DRB Application No.: 07DRB-70215 (SBP)
Project Name: L'IL SQUIRRELS PRESCHOOL
Agent: GARLAN BRYAN ARCHITECT

3. Project# 1006780
07DRB-70215 MAJOR - SDP FOR BUILDING PERMIT

3. Project# 1006780
07DRB-70215 MAJOR - SDP FOR BUILDING PERMIT

GARLAN BRYAN ARCHITECT agent(s) for MATT PADILLA request(s) the above action(s) for all or a portion of Lot(s) 5, **JOURNAL CENTER PHASE 2, UNIT 1, L'IL SQUIRRELS PRESCHOOL**, zoned IP, located on HANCOCK CT NE BETWEEN WILCOTT AVE NE AND HAWKINS NE containing approximately 0.5016 acre(s). (D-17)

MONUMENT SIGN DETAIL
SCALE: 1/2"=1'-0"

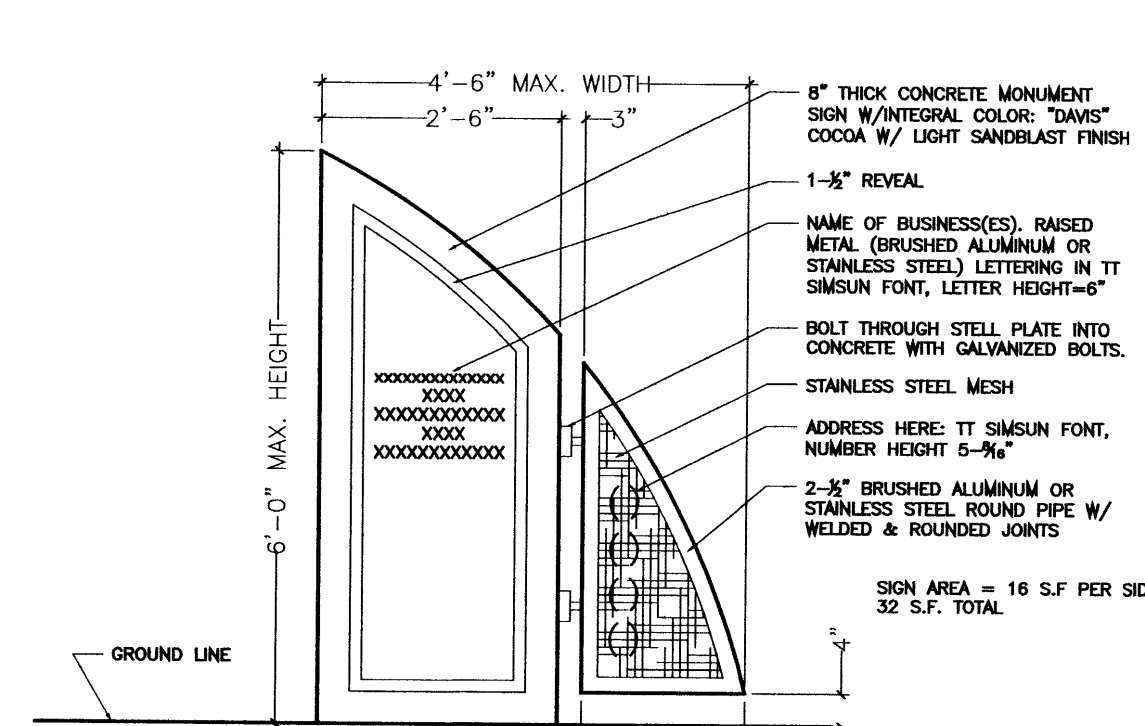
- 3. IP zoning allows one monument sign for each street frontage of at least 200 feet. See Section 14-16-2-19(A)(25) of the City Zone Code. According to the site plan submitted, this site does not meet this requirement.

SITE PLAN

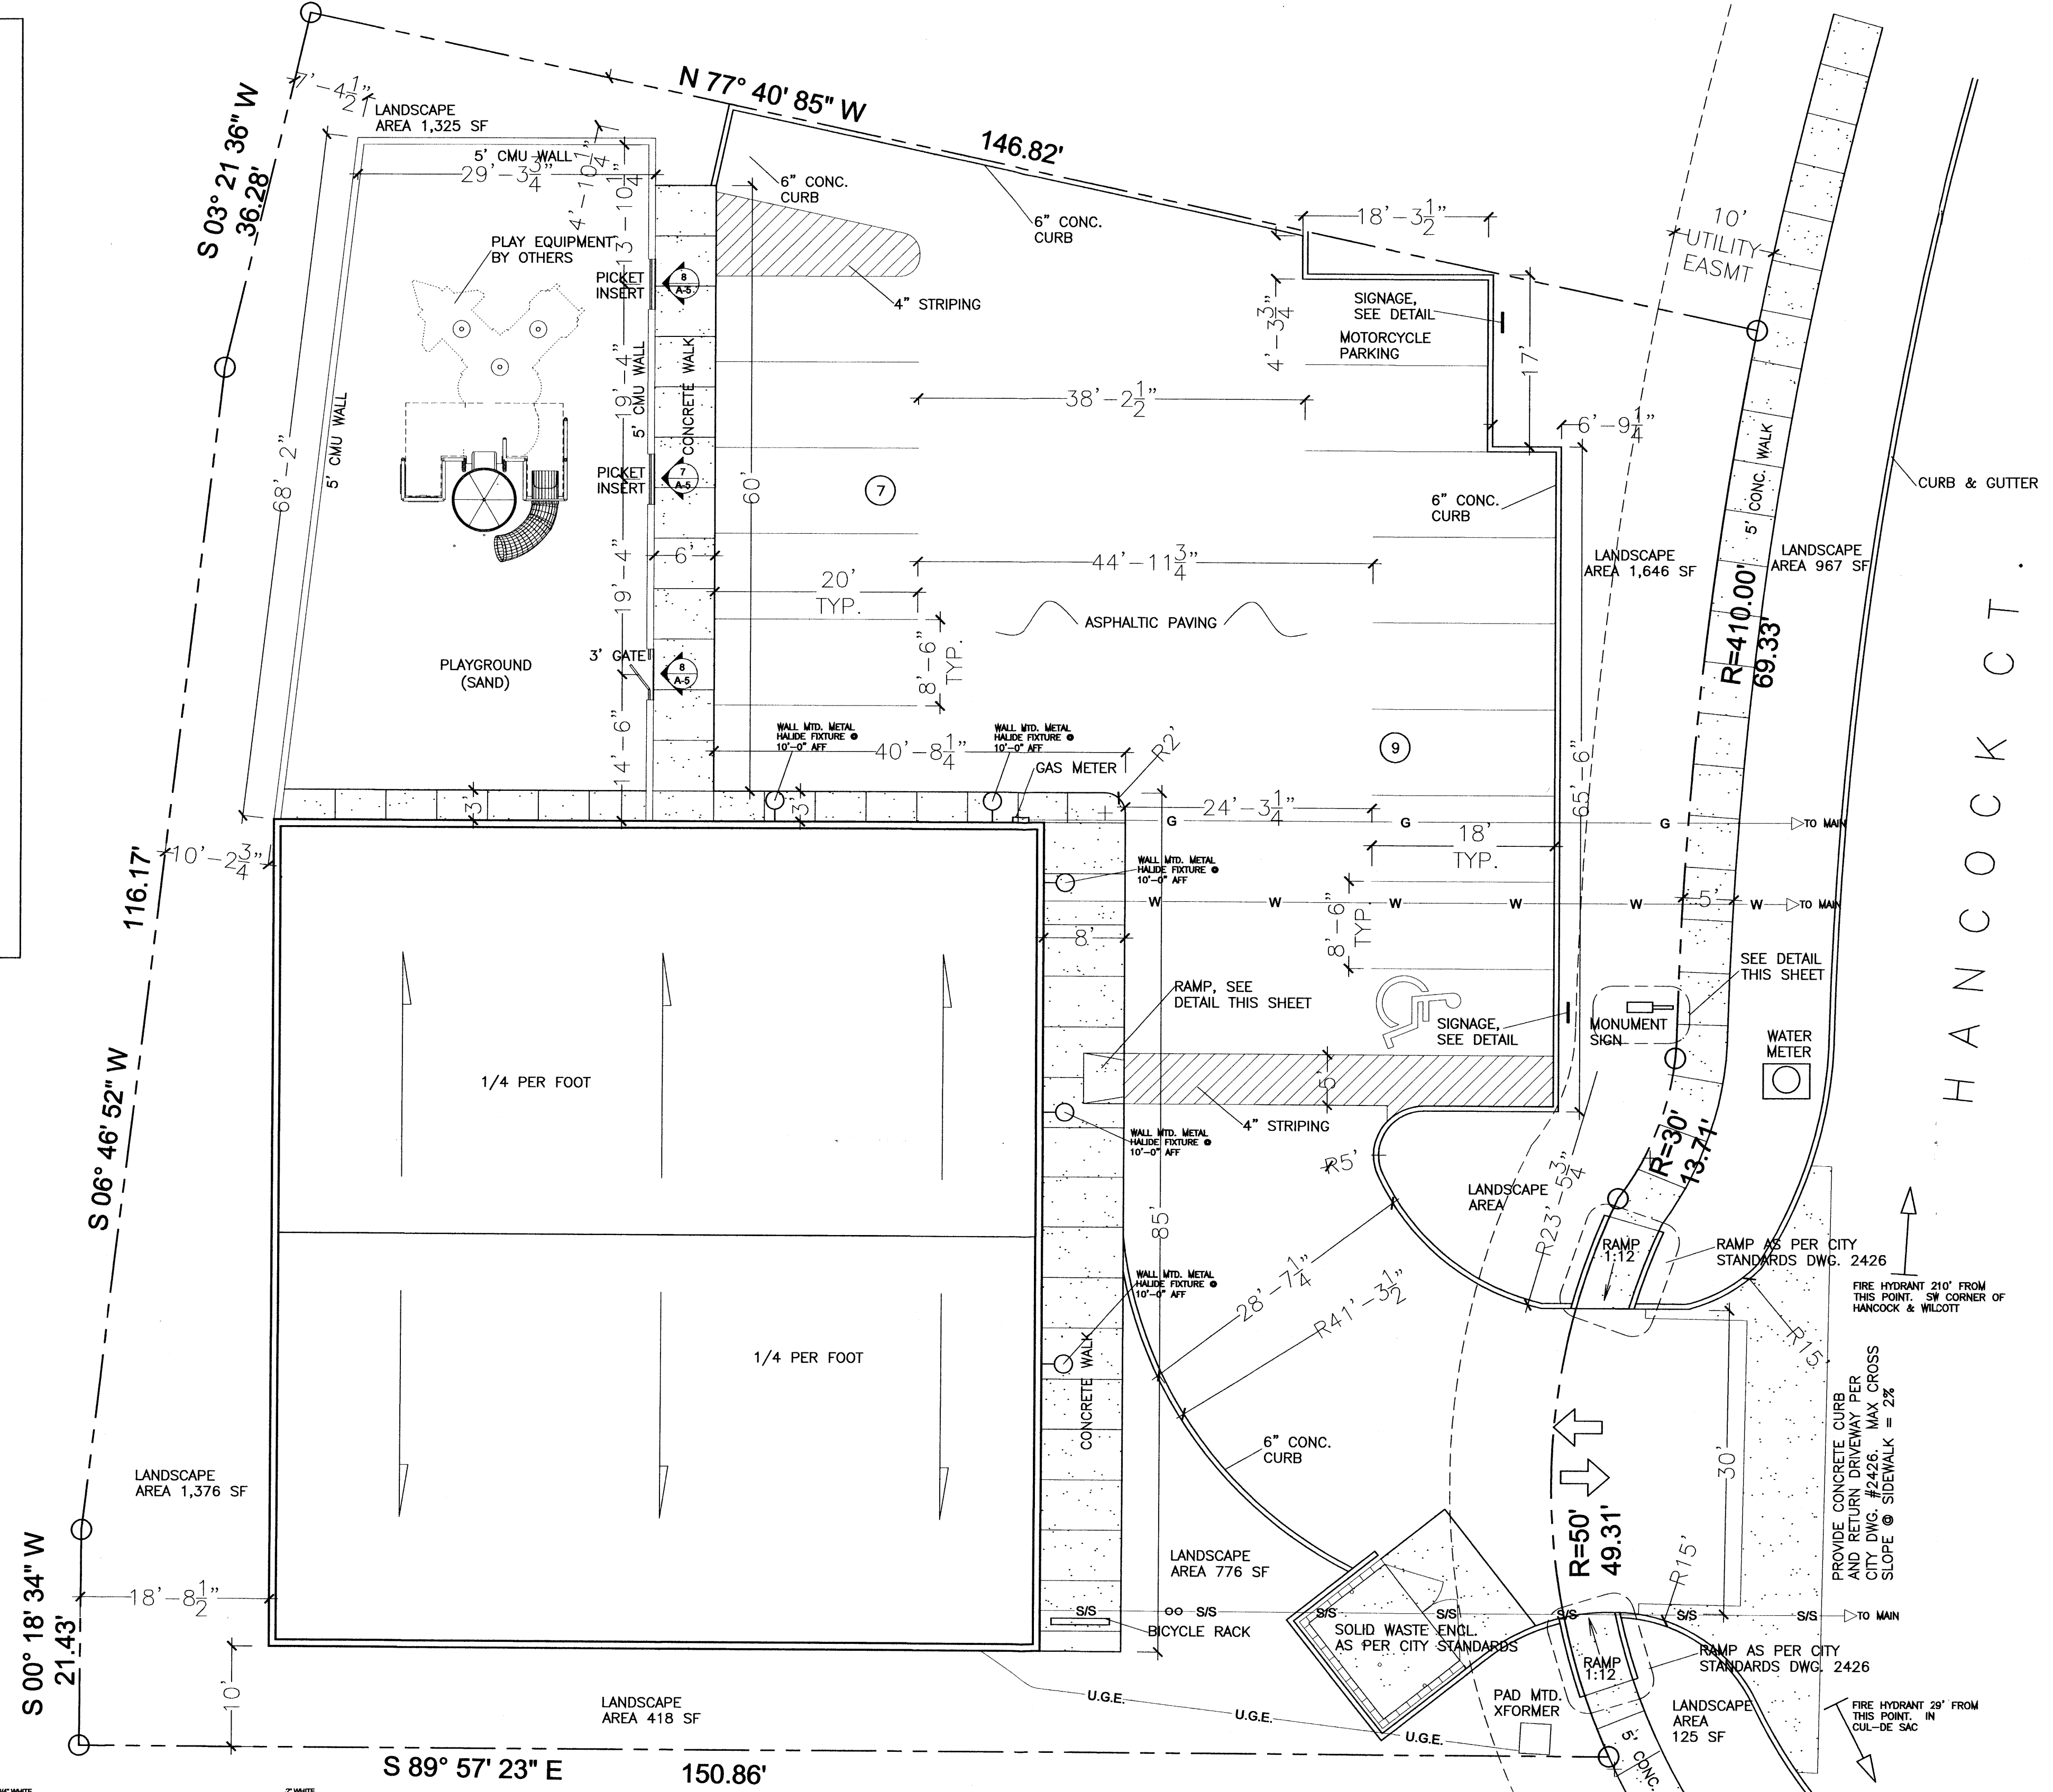
Other:
The wall surrounding the playground area should be increased in height (more than 5'). The increased distance should be with a material that offers visibility, such as wrought iron.

ADA space needs to be van accessible (8' aisle). Is the sidewalk existing? The ADA ramps also require truncated domes. The motorcycle stall should be 10' max. length and 4' in width. The parking stalls at the play area need bumpers or else provide 18' depth with an 8' sidewalk.

No objection to Site Plan approval other than show size of existing water tap and show existing sanitary sewer stub.

- 1. The SBBP Checklist lists the order of the pages of the site plan. In the future, be sure to follow that order.
- 2. The signature block is missing from the site plan sheet. The site plan sheet title should read "Site Development Plan for Building permit".

- 4. The building total square footage and the use should appear on the building on the site plan sheet.
- 5. What type of outdoor lighting is planned?
- 6. The tree well detail (or planting detail) is a required element of the Landscape Plan.

L-1 LANDSCAPE PLAN

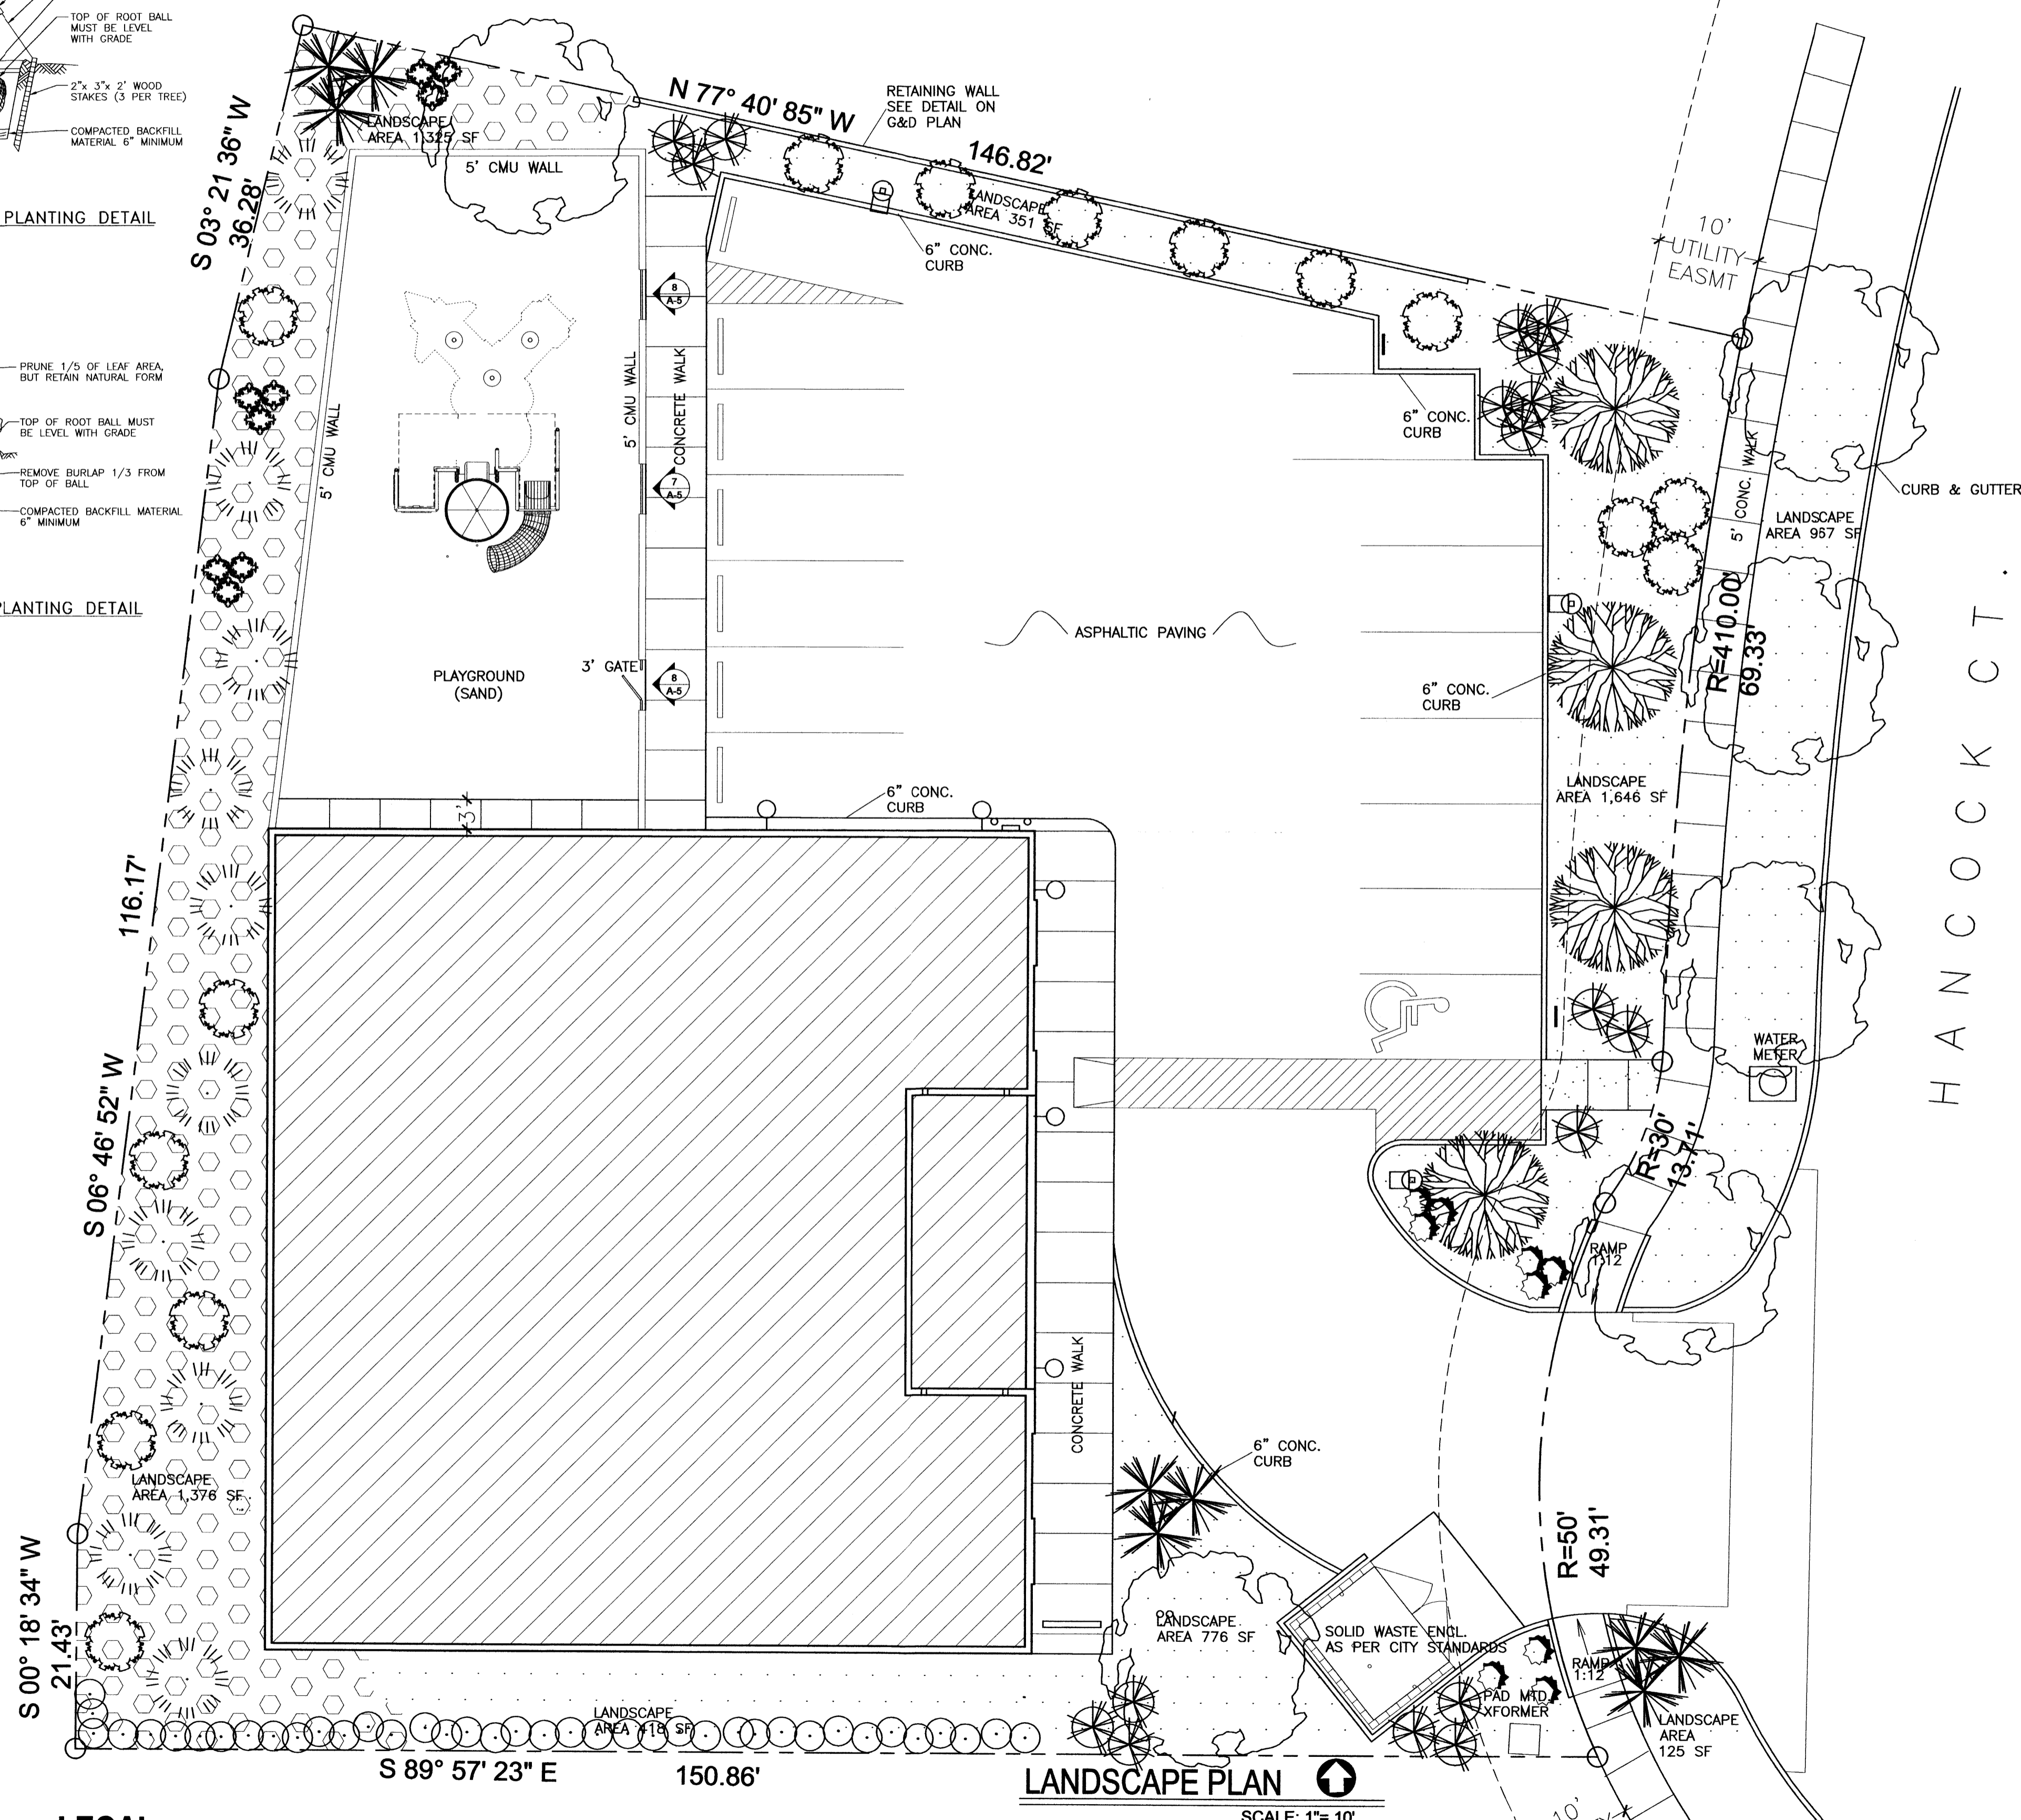
Landscaping issues:
Landscaping should be low-level at maturity, not conflicting with area lighting and not obstruct walkways, parking lots, building entrance and play areas.

- 7. Santa Fe Brown gravel is required to a minimum depth of 3 inches. Indicate in the note on the Landscape Plan.
- 8. The building elevation sheet is very sparse in details, including specific colors.
